## **SSD 6010 - One Residential Building (Student Accommodation) within Darling Drive Plot**

**Submission by:**

**21 July 2013**

SHADOW DIAGRAMS: PERSPECTIVE, SHOWING THE PEAK, WINTER SOLSTICE

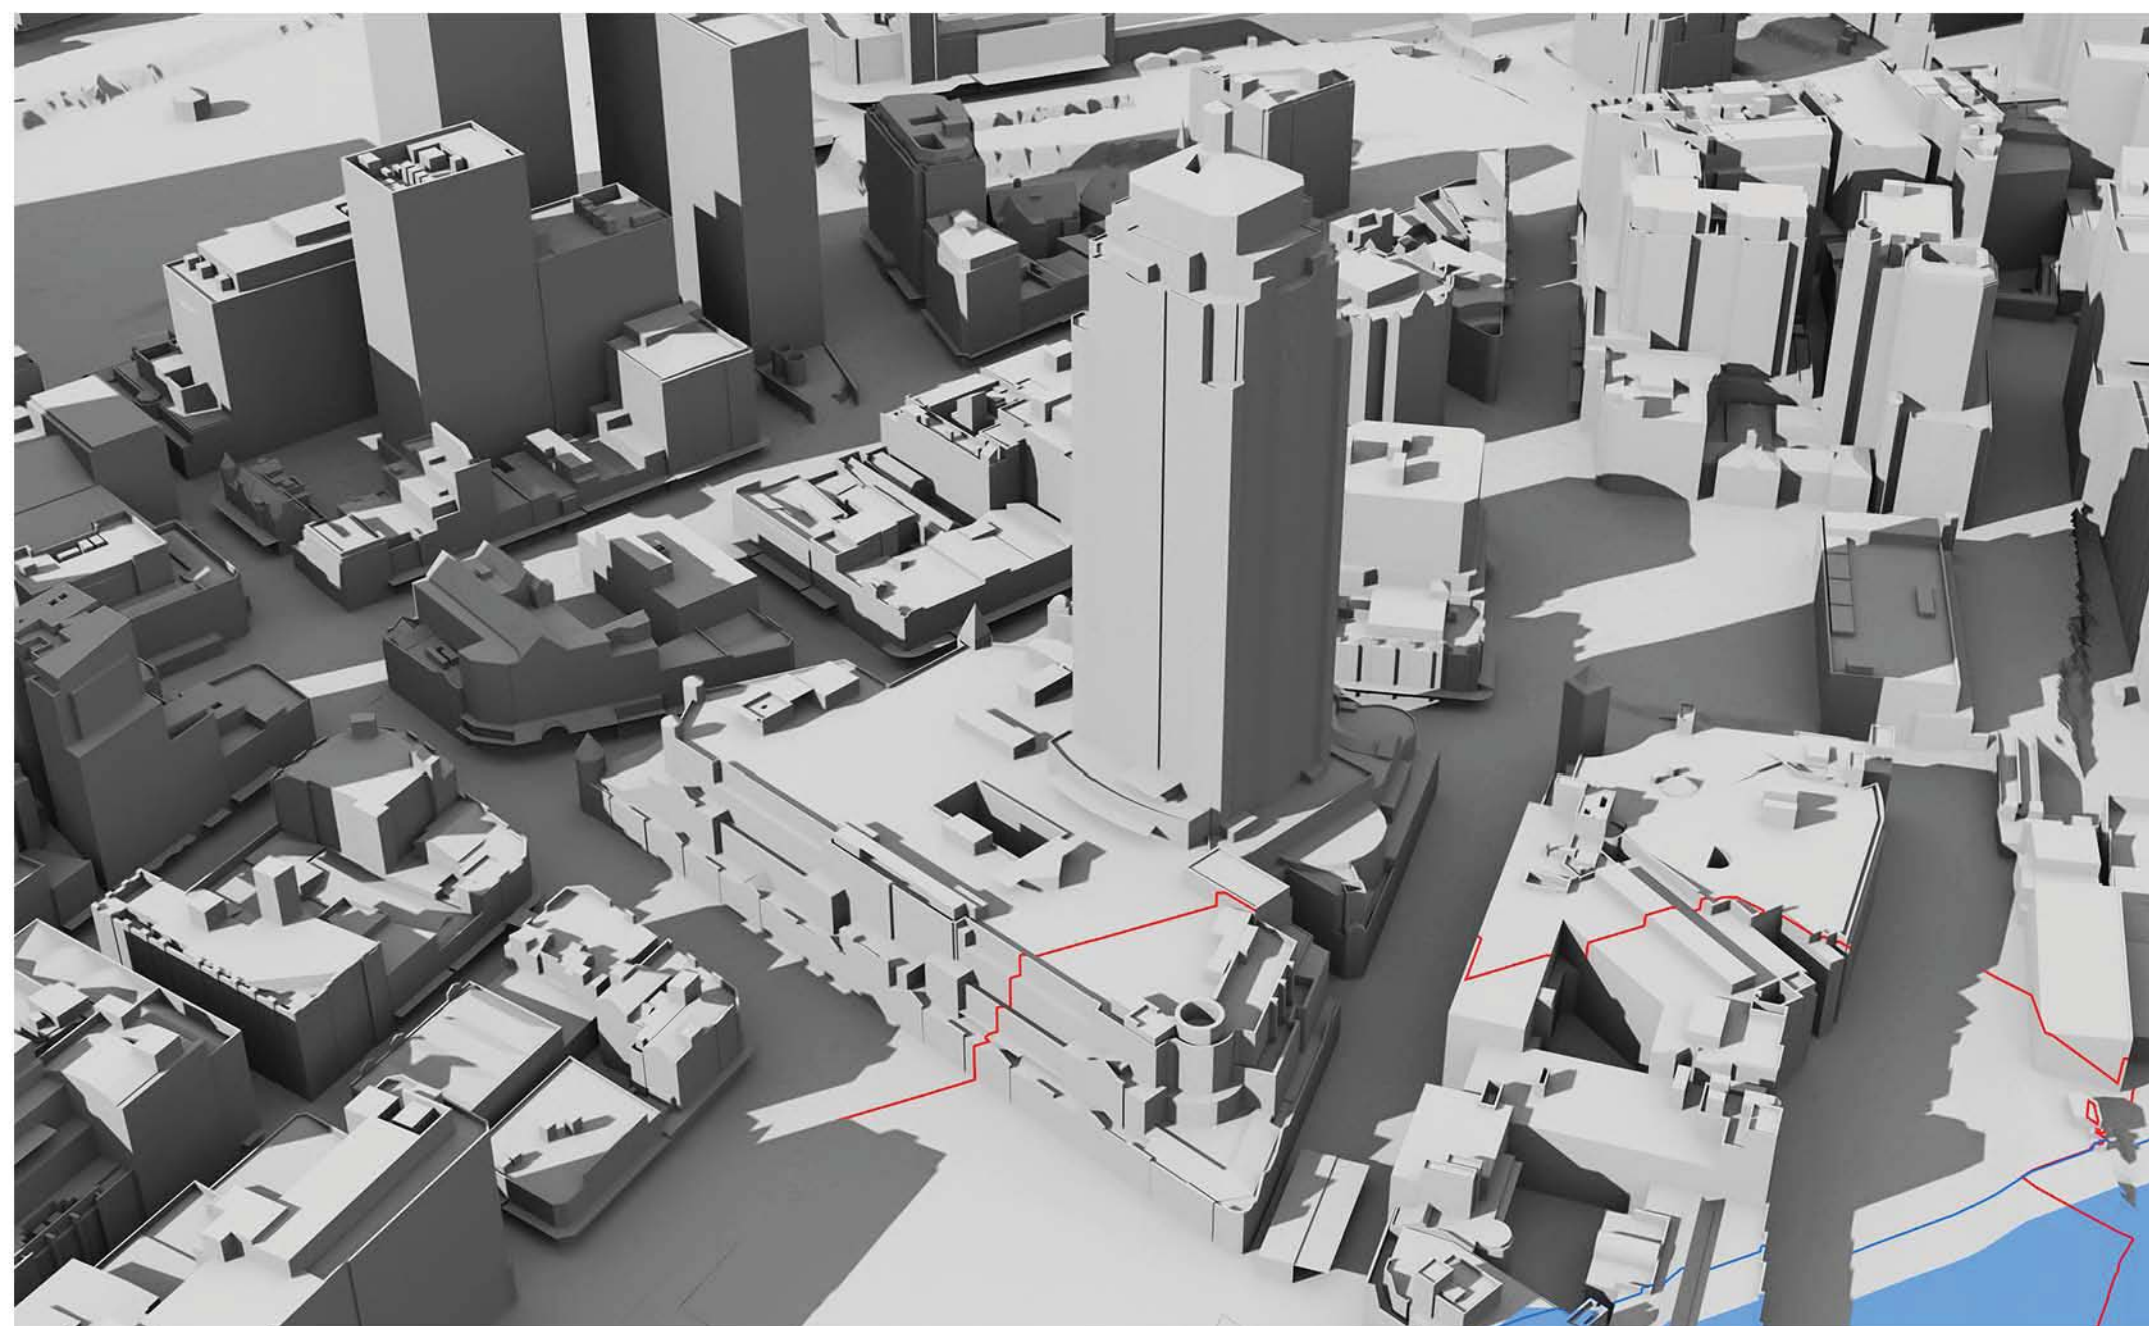
At 9am, 10am and 11am the west façade is totally in shadow due to other parts of The Peak building itself.

At 9am, 10am and 11am the west façade is totally in shadow due to other parts of The Peak building itself.
